Case Officer: Lewis Bankes-Hughes **Recommendation:** Approve

Applicant: Heyford Park Settlements LP

Proposal: Reserved Matters to 10/01642/OUT - Dorchester Phase 7B, comprising the provision of 6, two-bedroom and 3, three-bedroom affordable dwellings with associated landscaping, car parking, infrastructure and external works.

Title: Detailed Planting Proposals  
Parcel 7B

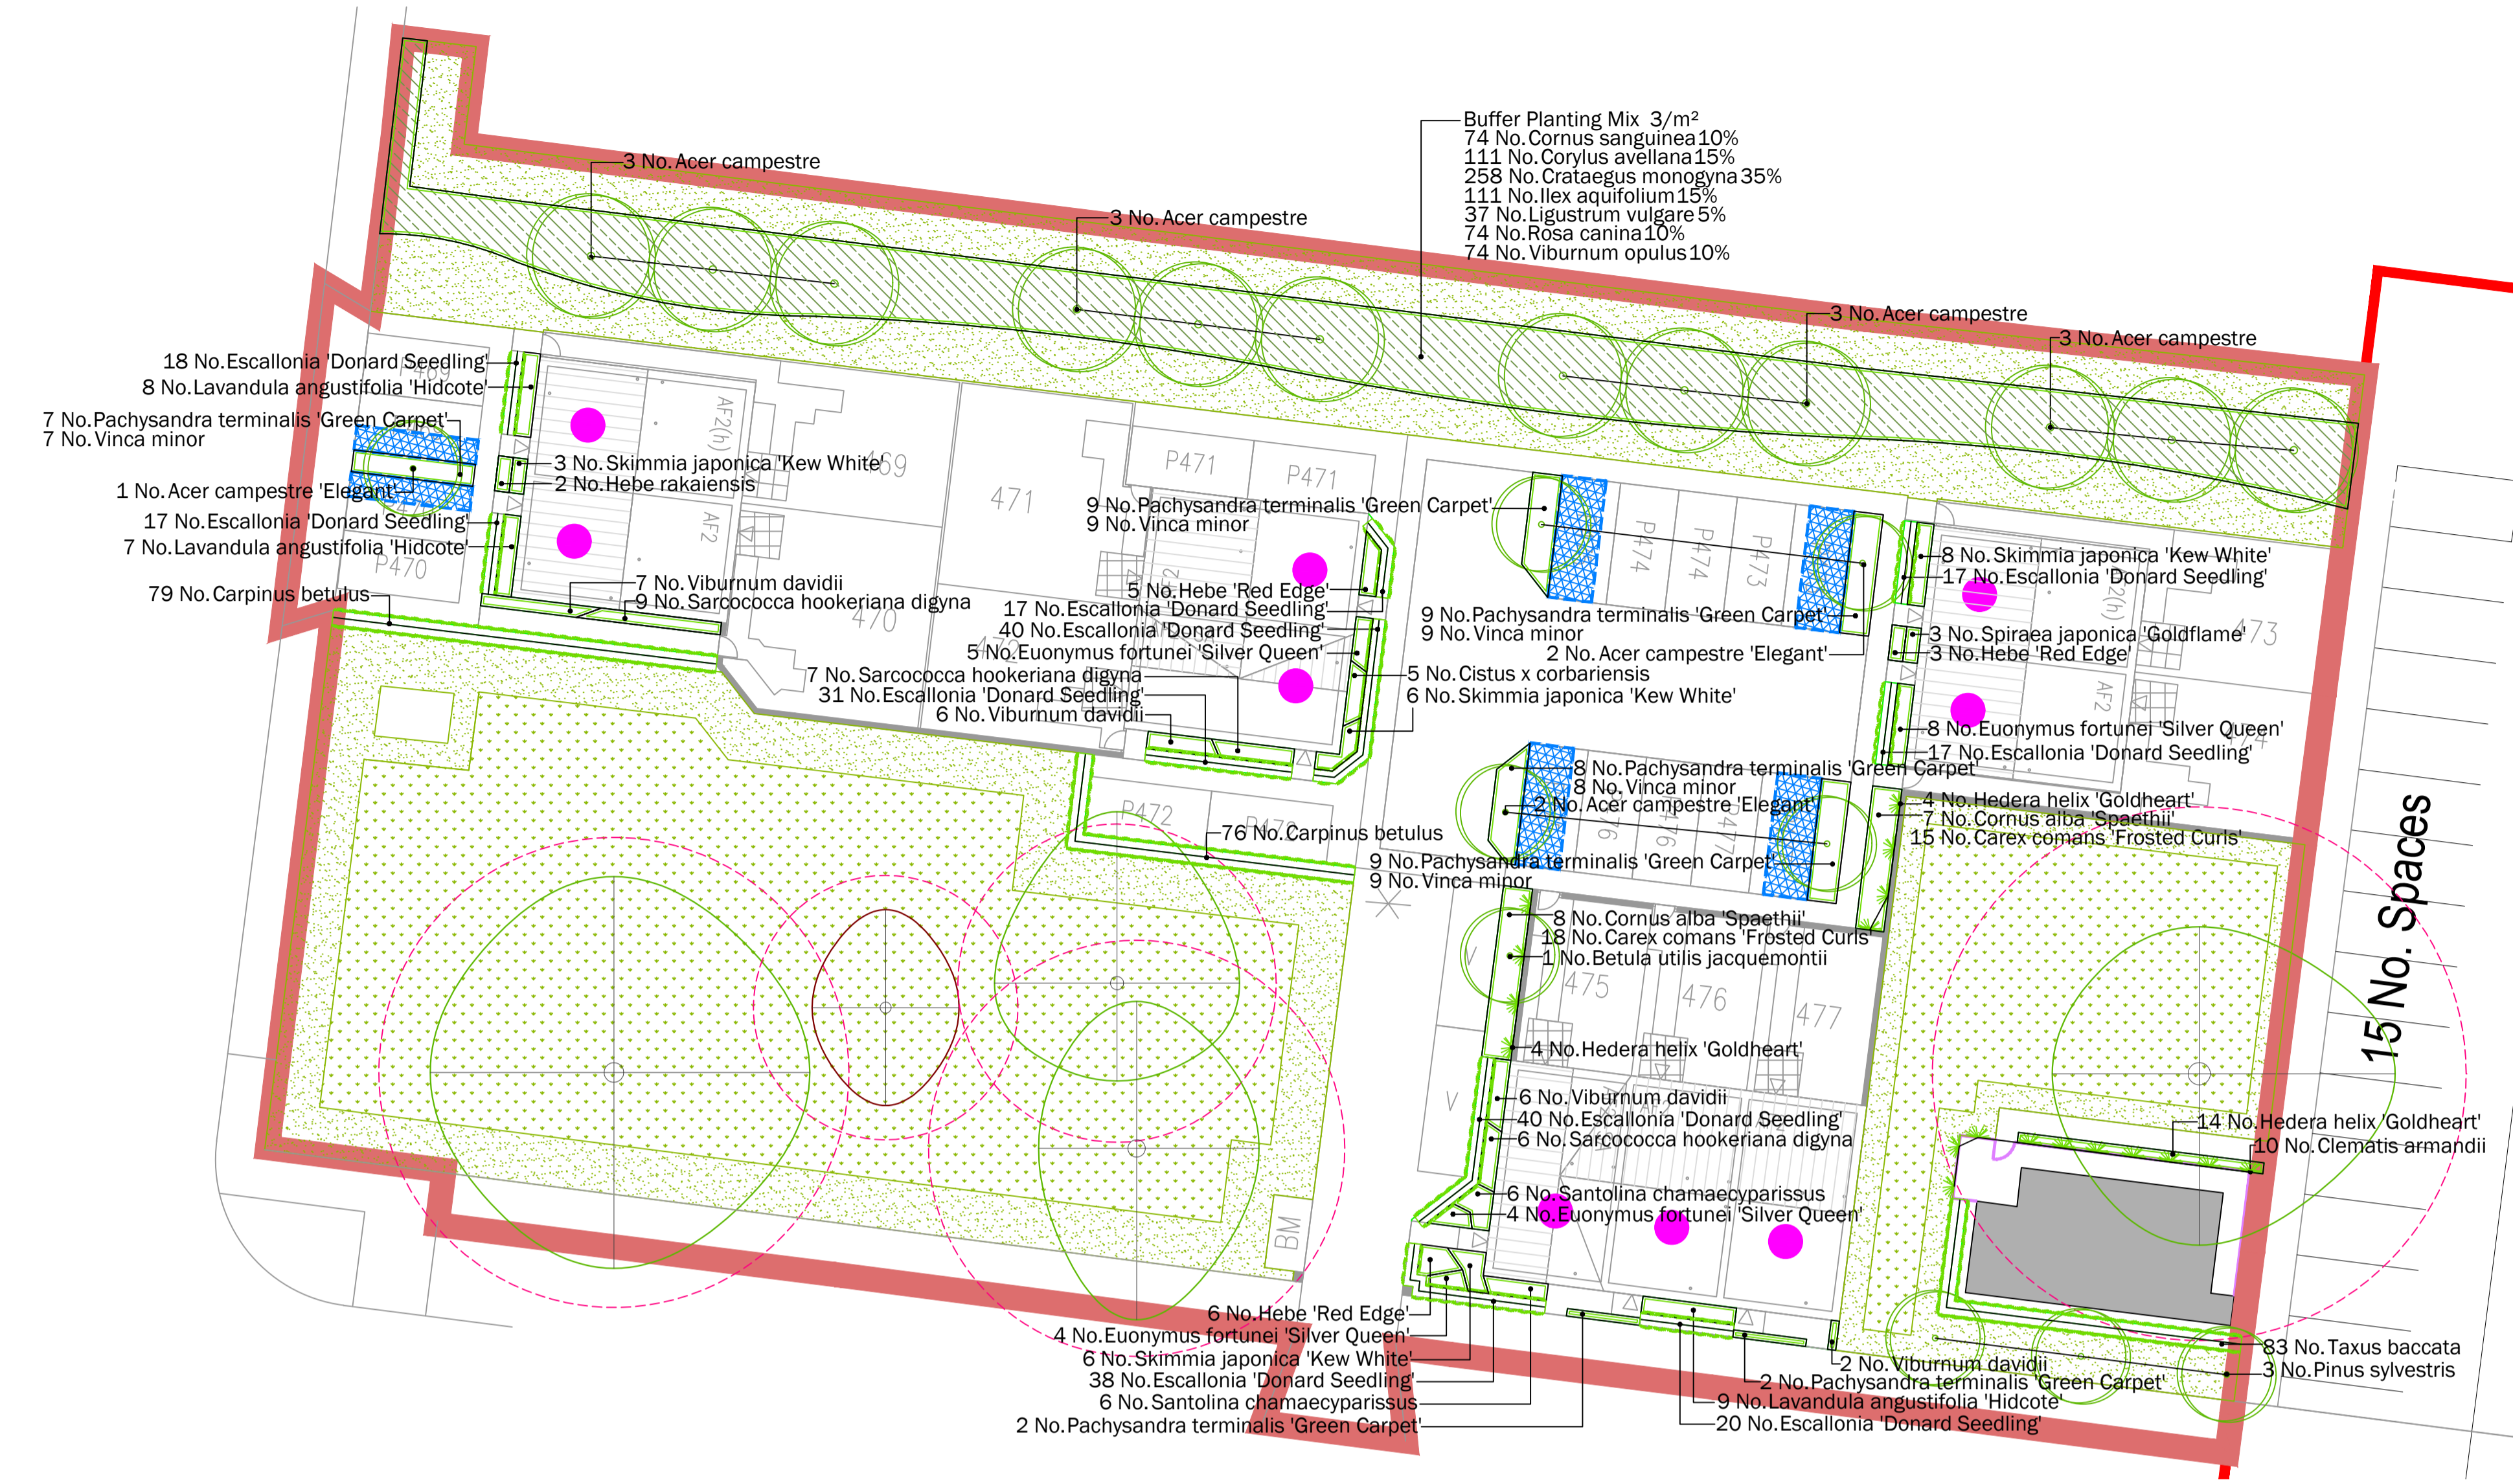
Rather visually onerous walling that requires mitigation with structure planting: shrub border and climbers. Let us see the planting detail in respect of the outer side of the wall to the boundary of plots 470, 472 474, and 477.

Delete the Betula tree from the area near the wall to plot 475 because of possible structural damage to this wall by tree roots and soil shrinkage.

Remove the 3 scots pines and the yew hedge to allow clear physical access for maintenance of the substation. For screening of the substation from Camp Road the existing hedgerow to be ended along the frontage for this purpose – planting details are required.

Remove all clone trees from the scheme, due to reasons explained previously, i.e. substitute *Acer campestre* for the A. c. 'Elegant'

There is no proposal to plant climbers on the garden walls of plots 470, 472 474, and 477. I think this is essential to visually mitigate the walls.

Remove the tree *Pinus sylvestris* from the southern elevation of the substation because they will grow too large for the space provided and with the retained tree north of the substation structural damage may occur due to soils shrinkage. The yew hedge is to be retained for mitigation of visual impact.

6. Prior to the commencement of the development hereby approved, and notwithstanding the details submitted, a revised landscaping scheme incorporating the recommendations made by the Landscape Officer shall be submitted to and approved by the Local Planning Authority. Thereafter, the development shall be undertaken in accordance with the approved landscaping scheme.
